Submission to EIS of Stratford Mine Extension Project  
Application Number SSD-4966

Affected property 345 Glen Rd Craven - Notated Receiver on EIS - Property 47

Submission

Indicative noise contours for night-time operations under adverse meteorological conditions for Years 2, 7 and 10 are presented in Figures ES-4, ES-5 and ES-6, respectively.

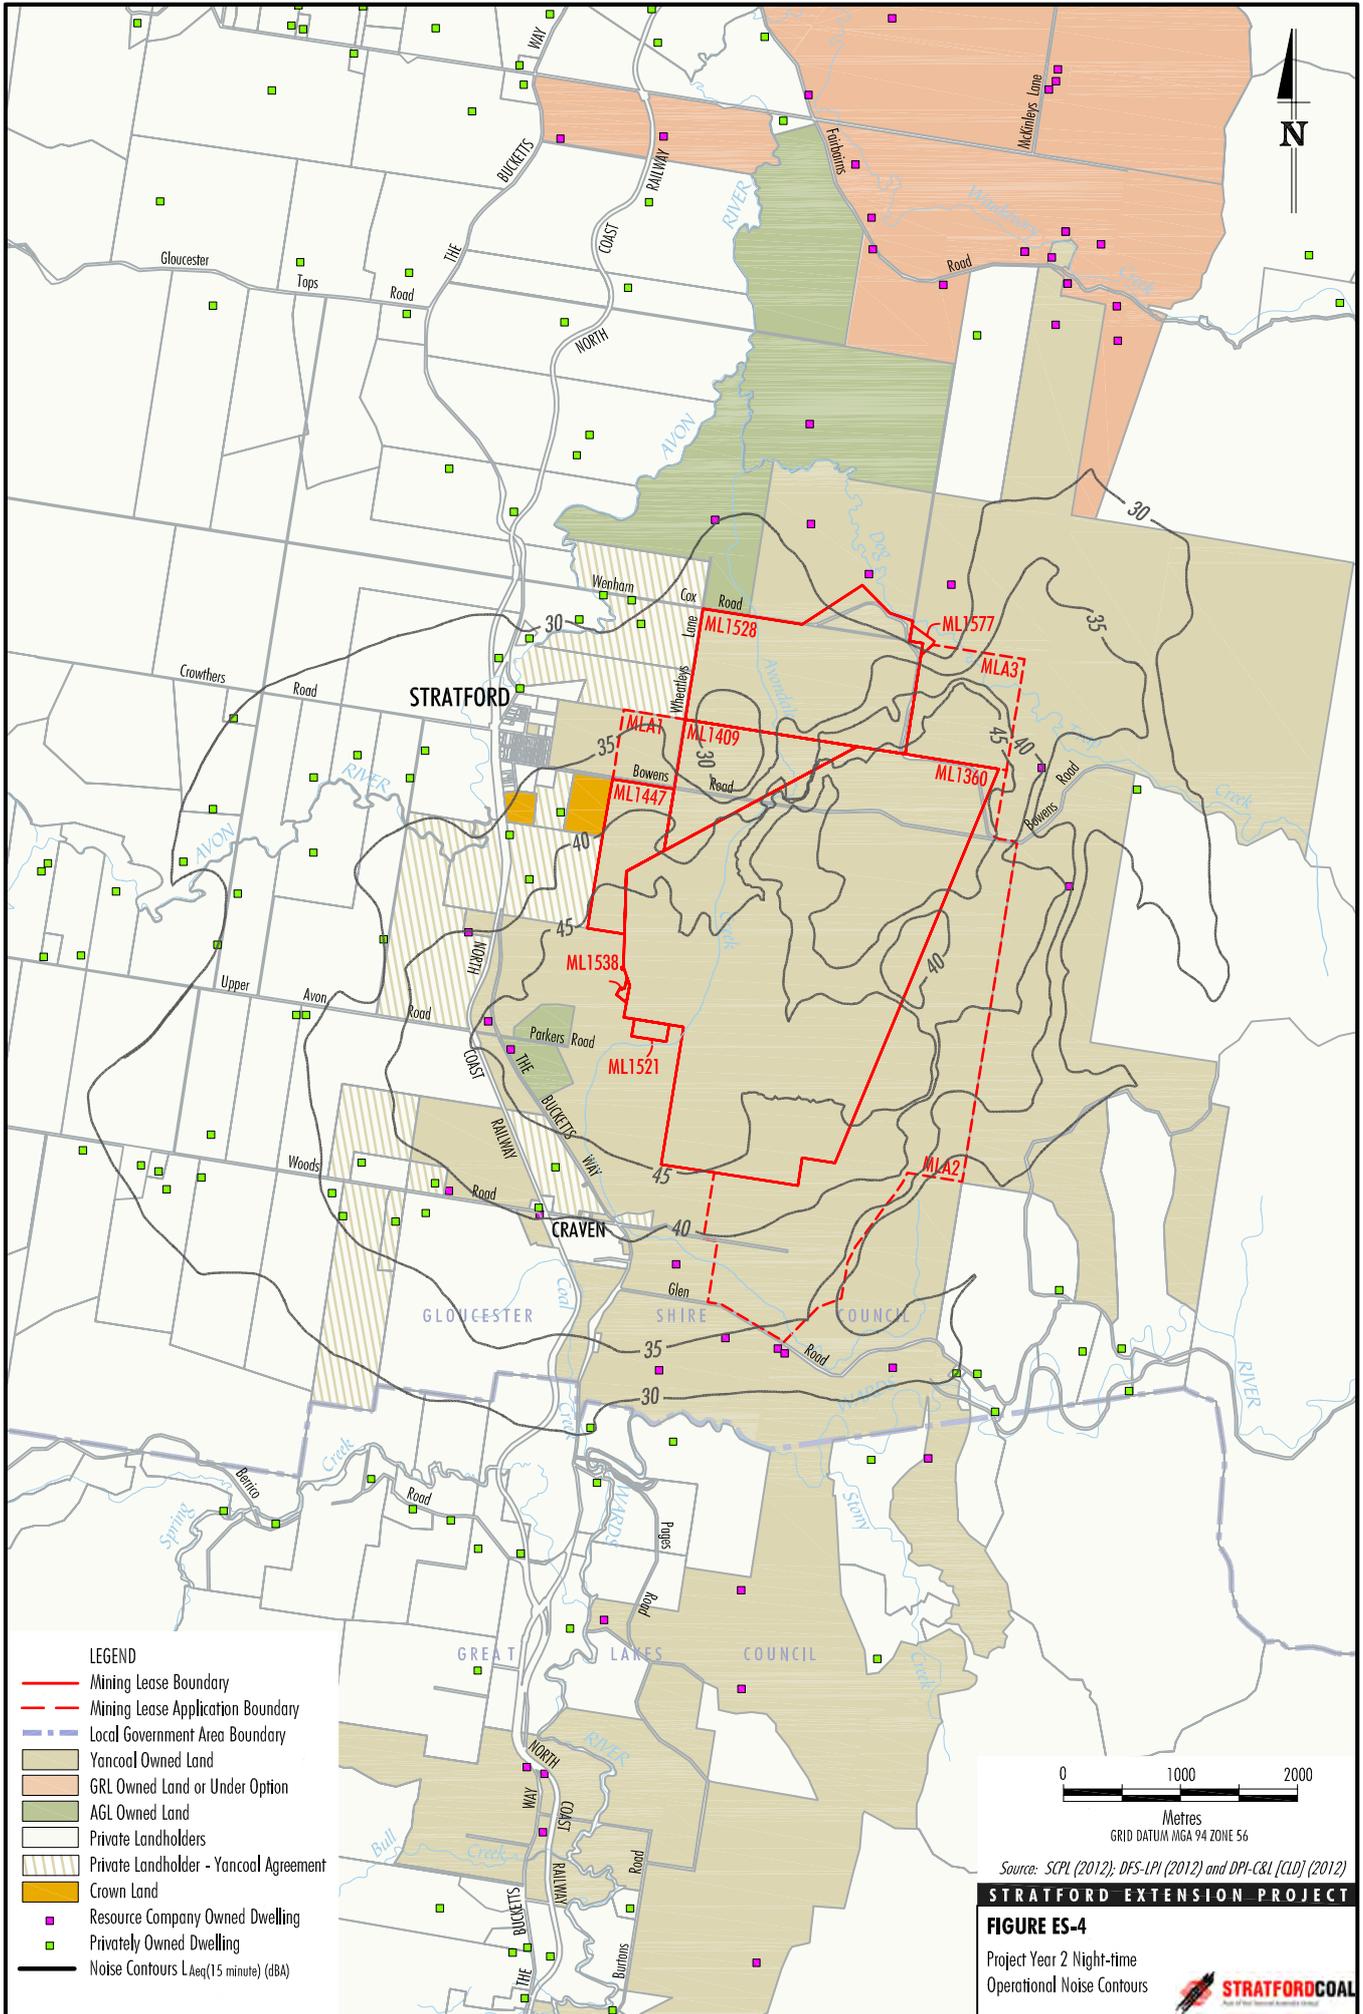
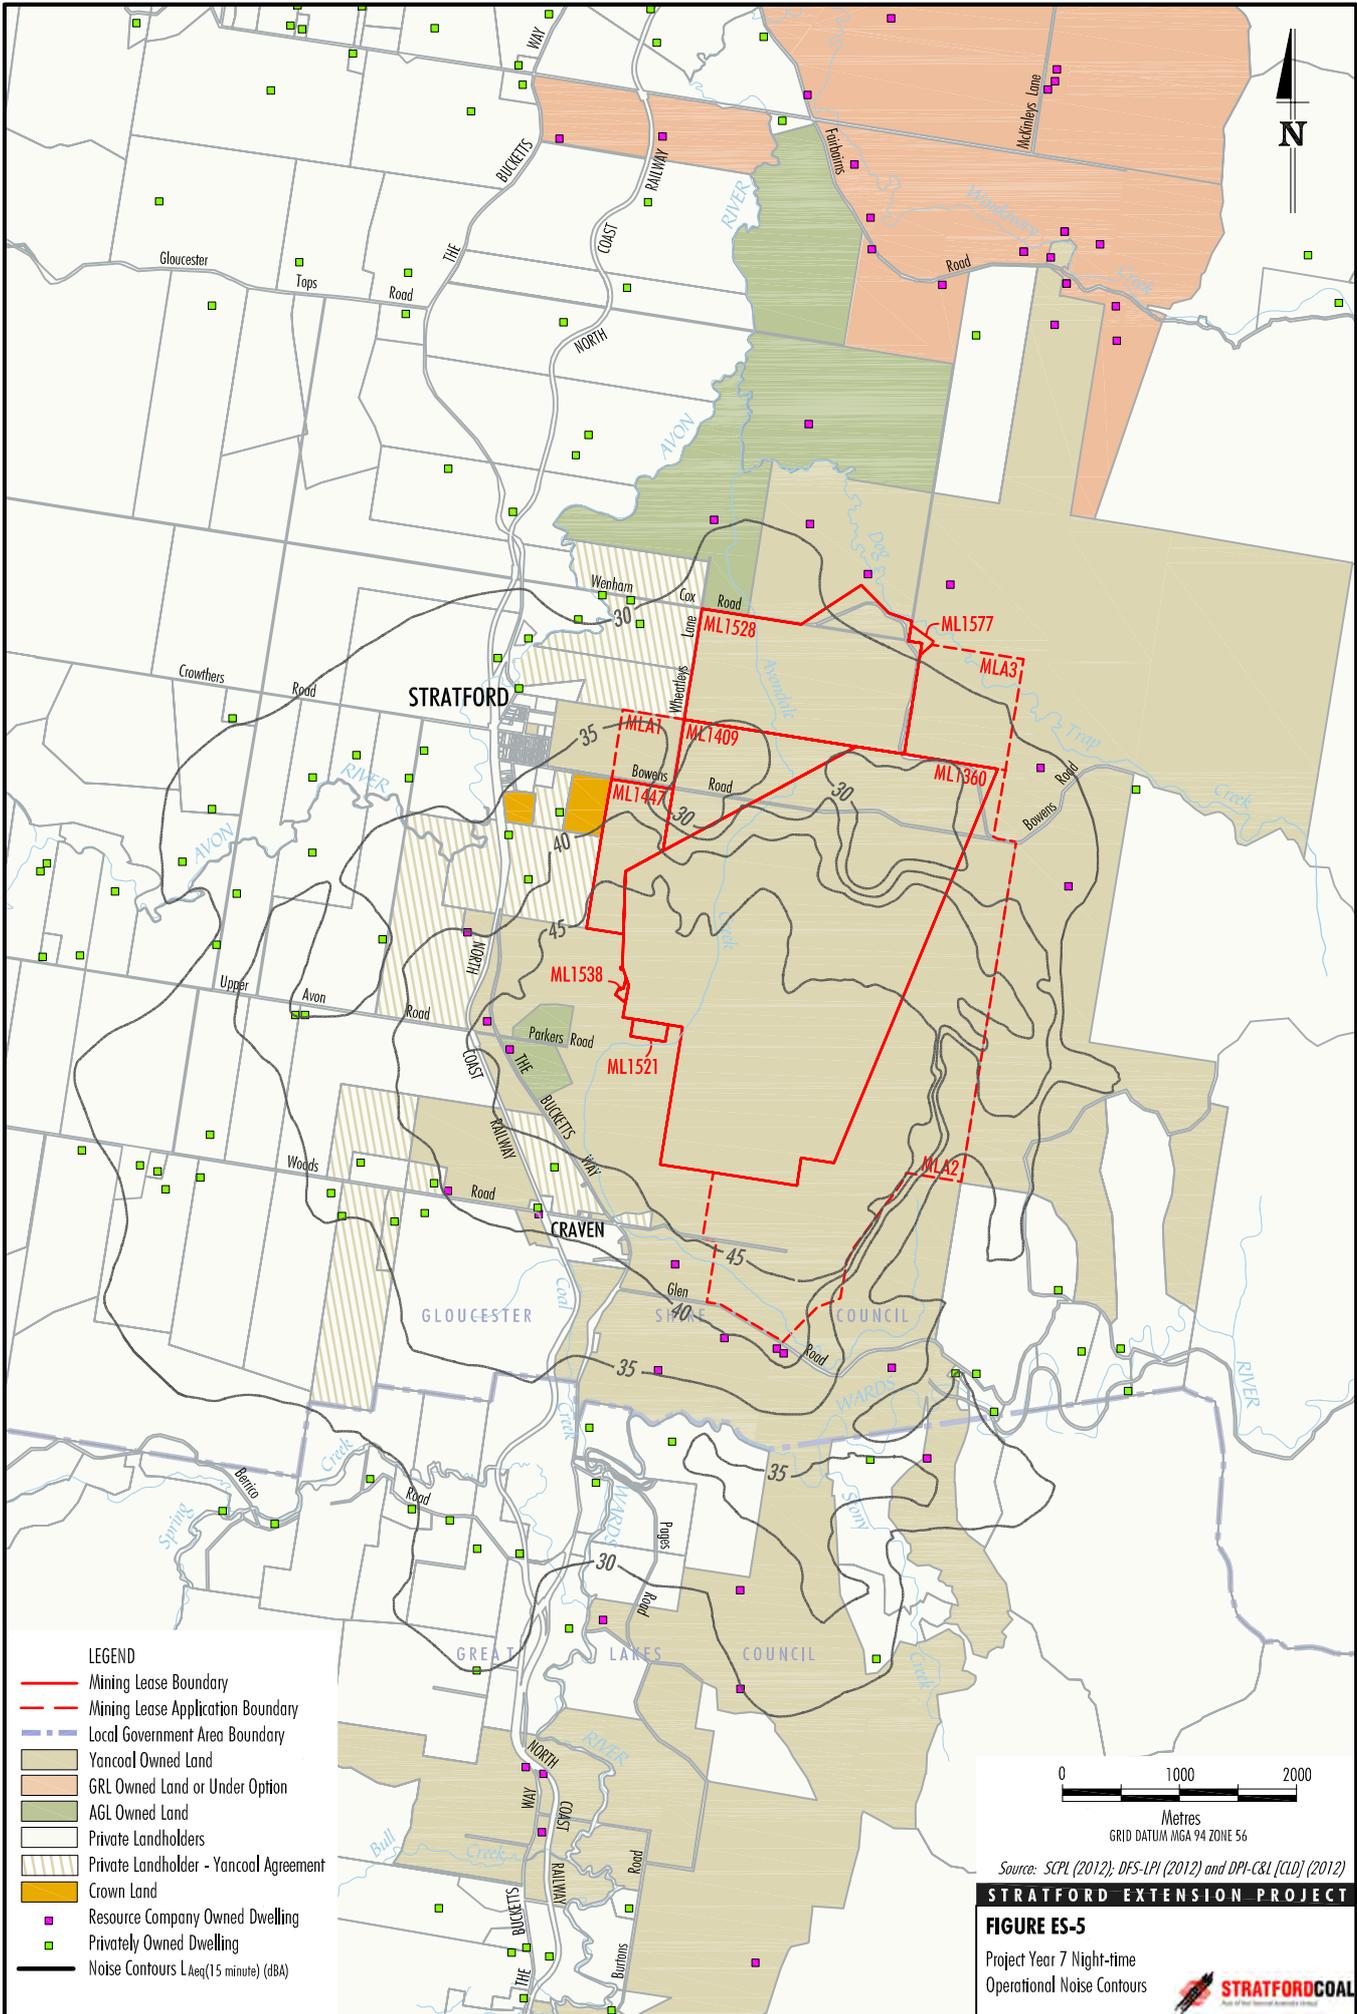
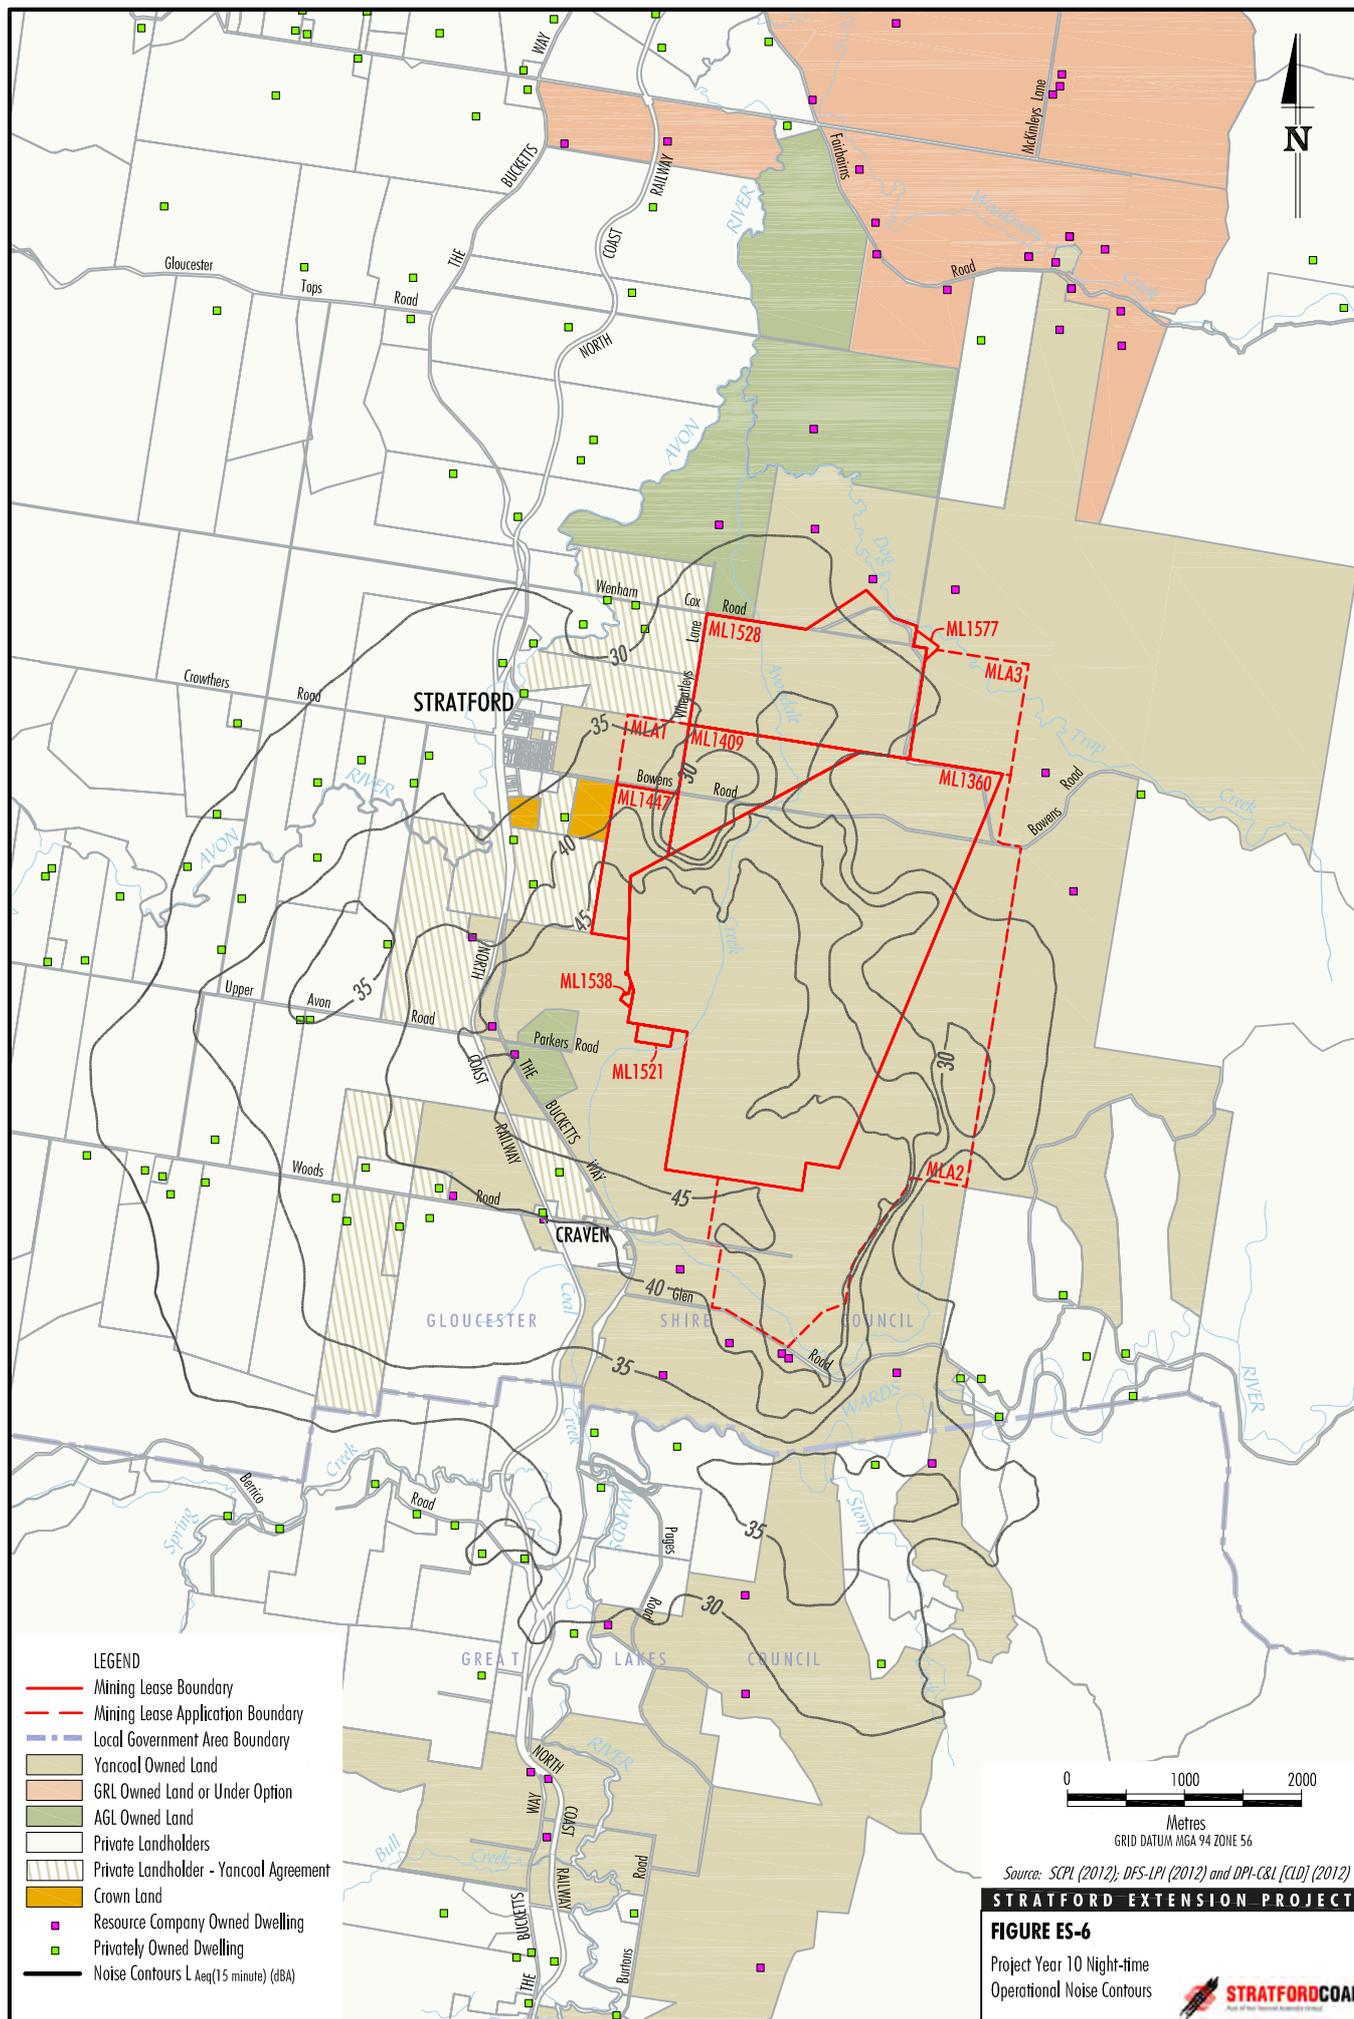
EIS contains Night time noise contour maps ES-4(2yr),ES-5(7yr) , ES-6(10yr). Our farm Receiver 47 in relevant distance to SEP falls between receiver 60 and receiver 19(32). As the SEP is mined the distance decreases between operations and the 3 receivers. Also of relevance is that the SEP moves adjacent to decreasing geographic impedance and additionally stated within the EIS " night time inversions are a feature of the area" . However notwithstanding the above facts there are illogical relevant differences between these receivers i.e. there is significant increase in noise contours for receivers at 19(32) and 60 but a relative decrease in noise contours for receiver 47 from 2-10 year period . Logical analysis would assume all 3 receivers should have increased noise levels as the noise source gets closer. This anomaly is evidence that modeling extrapolations into Glen Rd have rendered inaccurate the contour models .
